**HOUSING & PLANNING
SERVICES DEPARTMENT**

Application no: H14/1226/98

Description: Erect bungalow with garage

NOTICE OF ACCEPTANCE OF AMENDMENT

# E L E V A T I O N S

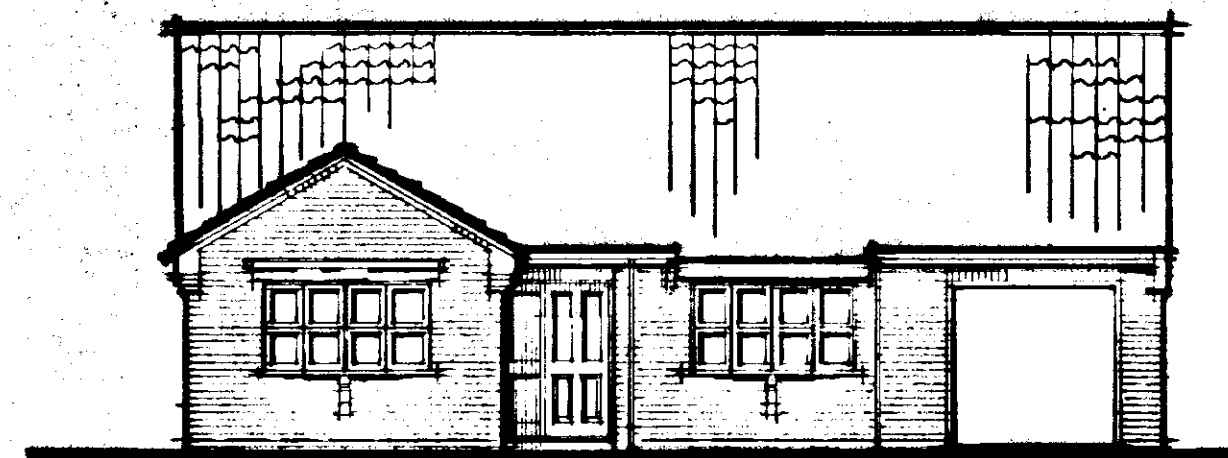
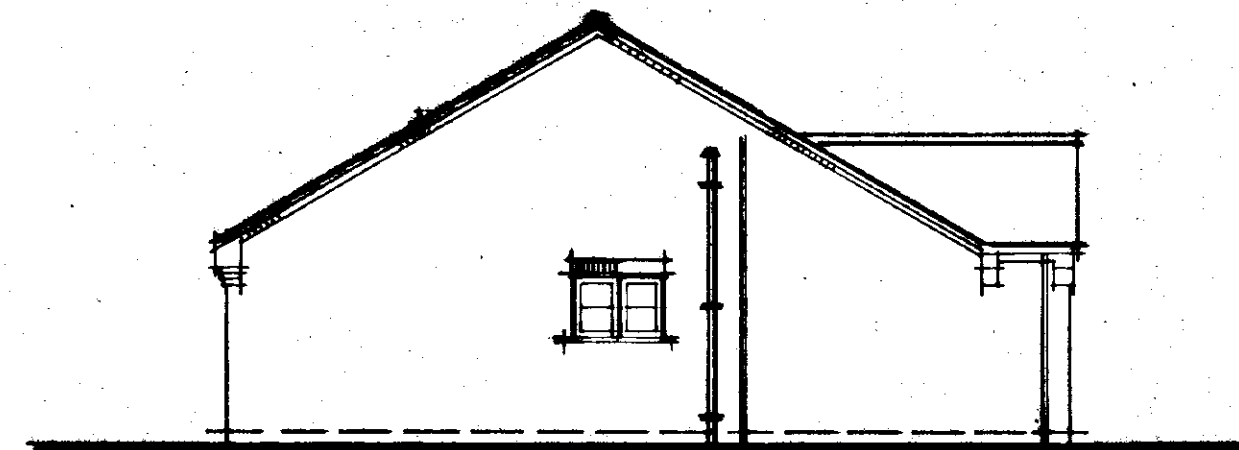
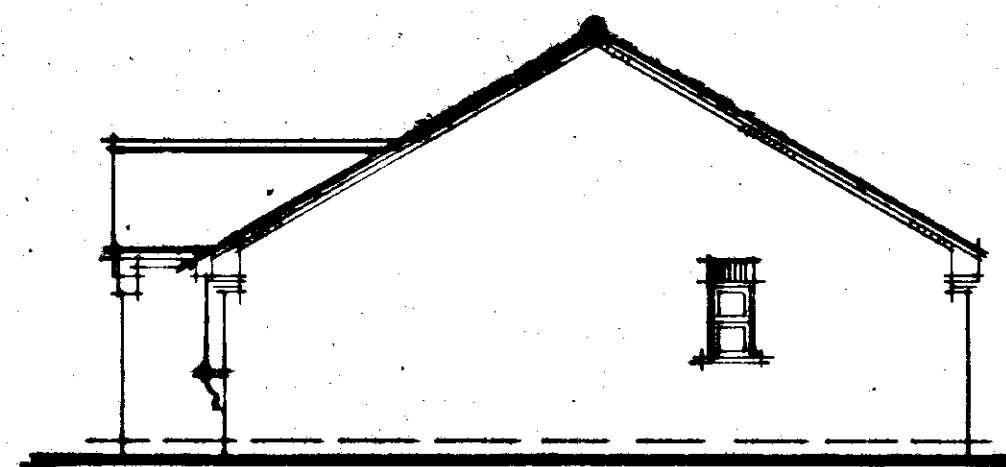
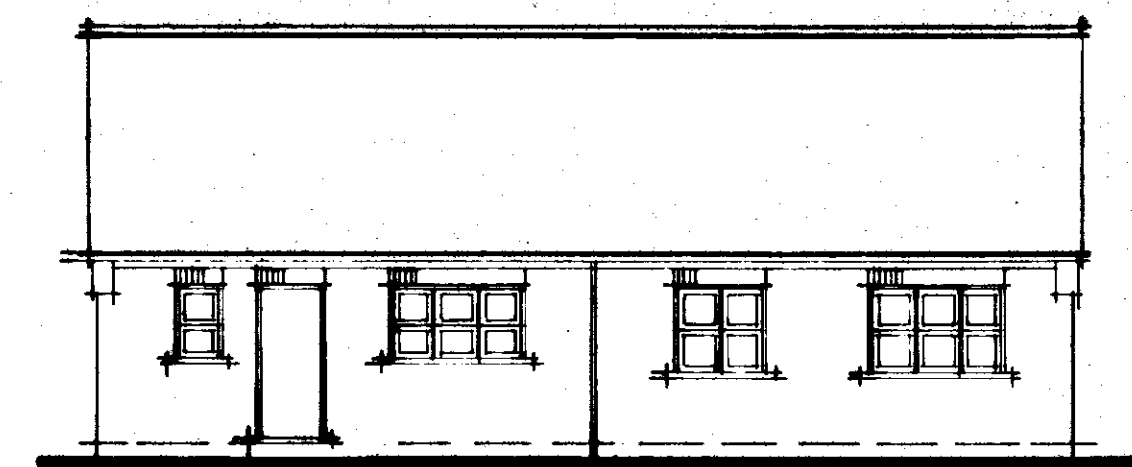
Amendment: Brick: Hanson (Butterley Heather Red Rustic). Tile: Sandtoft
Double Pantile. Change half hip to gable. (Dwg. No. 02C)

CHANGE BRICK TYPE + TILE
EJECT TO BRICK ENDS IN PLACE
OF HALF HP.

BRICK TYPE HANSON / BUTTERFLY
HEATHER RED RUSTIC. AS SAMPLE
SUBJECT RURAL PRACTICE - RUSTIC.

The amended details submitted in respect of the above proposal have now been considered and there are no objections to the amendment being implemented to the extent described above.
